From: Amy Myer <Amy.Myer@arun.gov.uk>
Sent: 28 February 2020 17:57
To: Planning.Responses <Planning.Responses@arun.gov.uk>
Subject: FW: P/111/19/PL - 209 Pagham Rd (2) - CONSERVATION OFFICER COMMENTS

P/111/19/PL

DRAWING TITLE
Floor plans as proposed

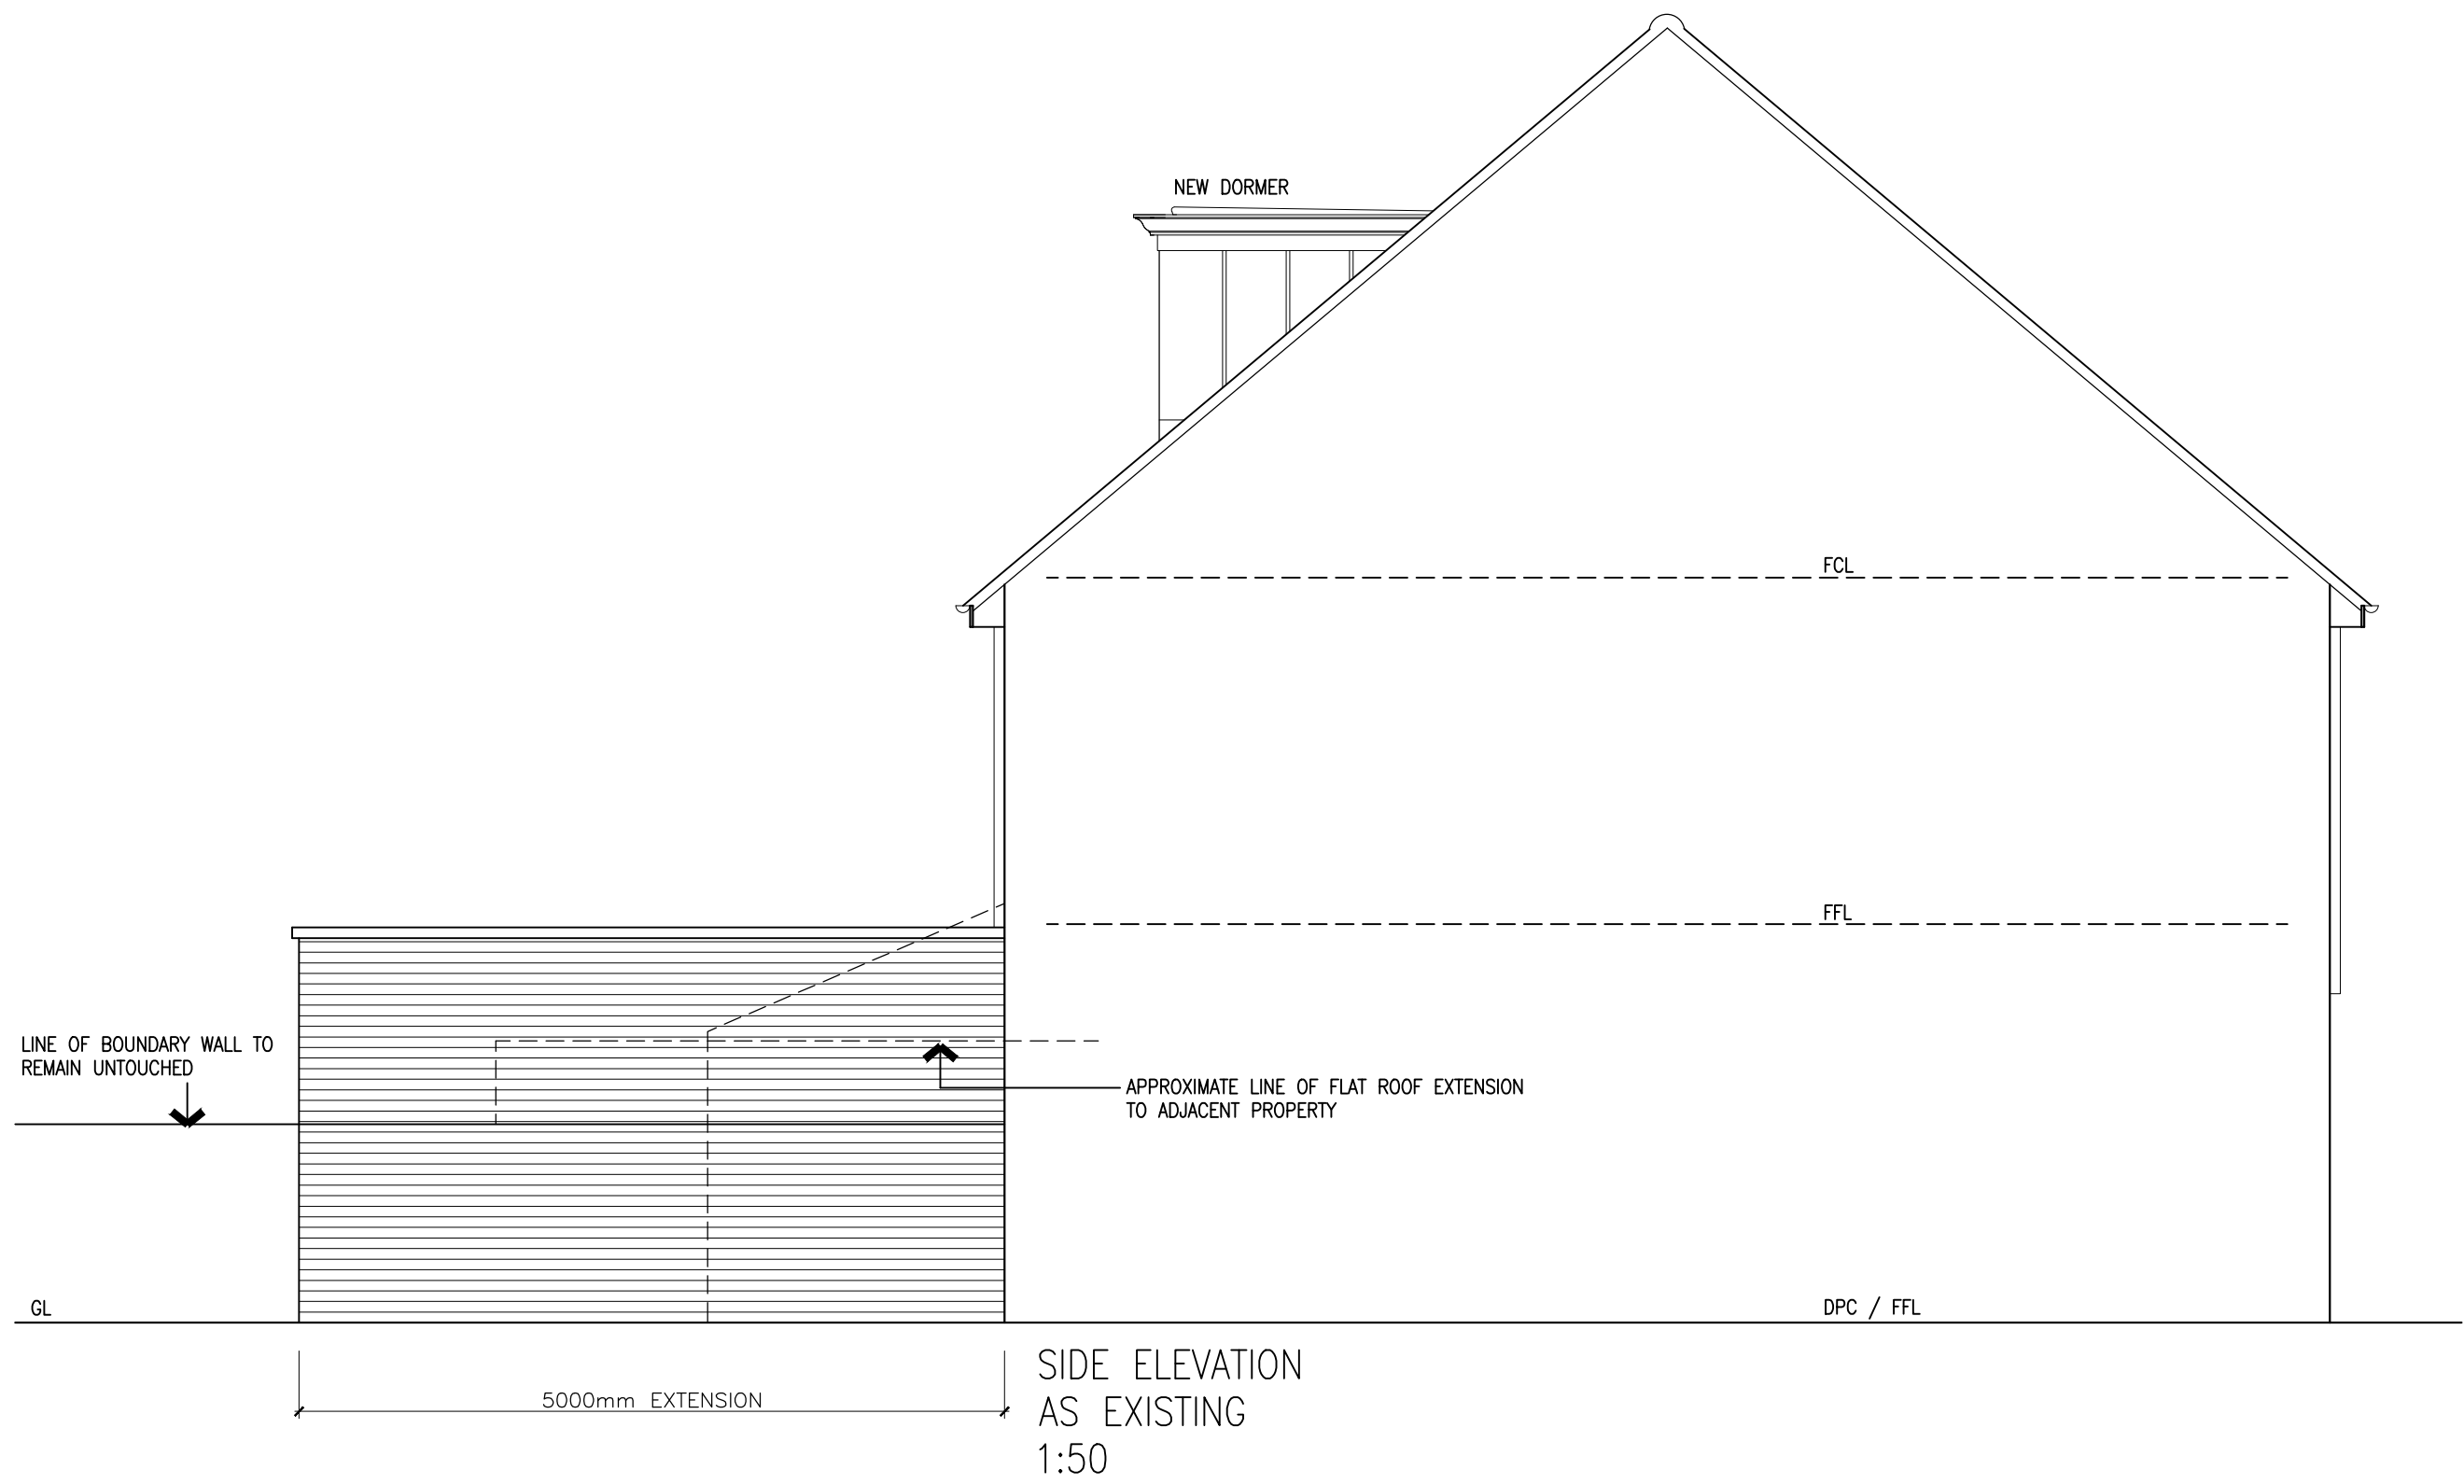
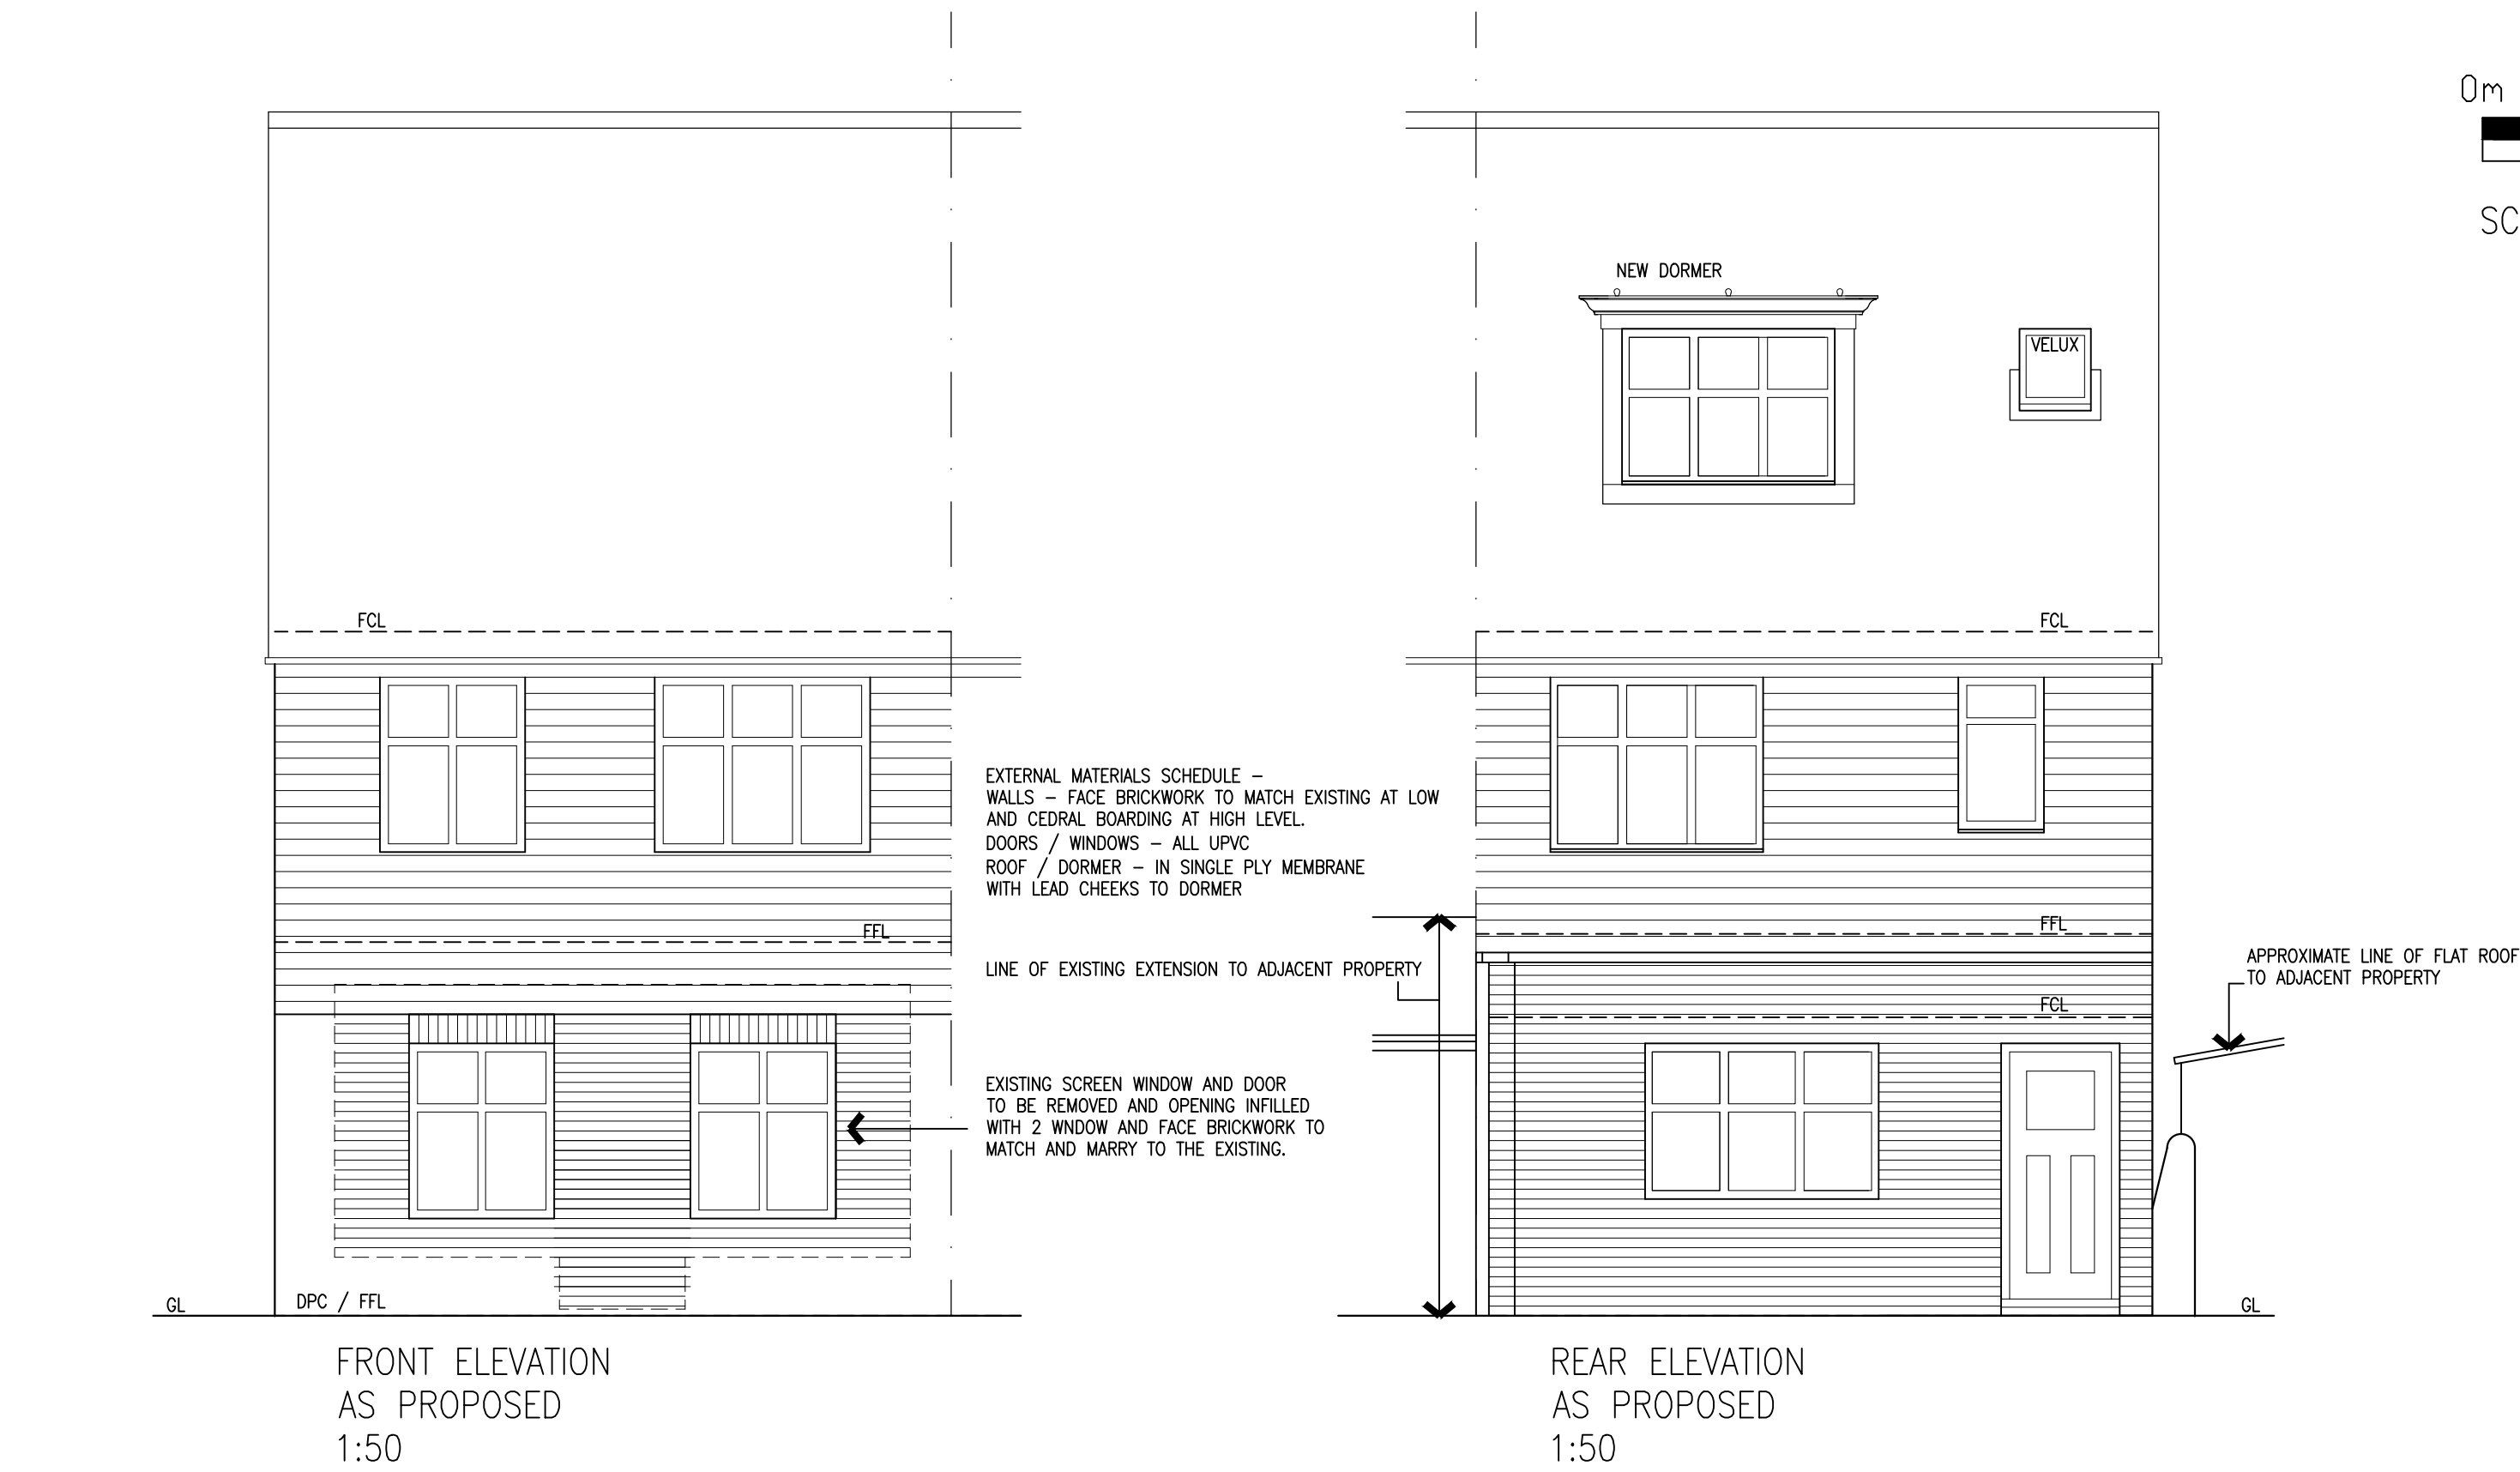
It would appear that the rear extension is to extend so that it abuts the curtilage wall of the neighbouring listed building. Development proposals such as this should ensure that they do not harm the wall either during construction, or afterwards through the design or use of materials. At present it is not clear if the works will harm the wall beyond covering part of its elevation.

The proposal would result in development extending even closer to the listed building than it does at present, which could cause some harm to the listed building.

At present, it is considered that there is potential for the development to harm the listed building/curtilage wall. This level of harm would be described as causing less than substantial harm in accordance with paragraph 196 of the NPPF (2018). Such harm would be on the lower end of the spectrum.

If you are minded to approve the proposal, the applicant should submit details of how the wall will be protected during the construction works.
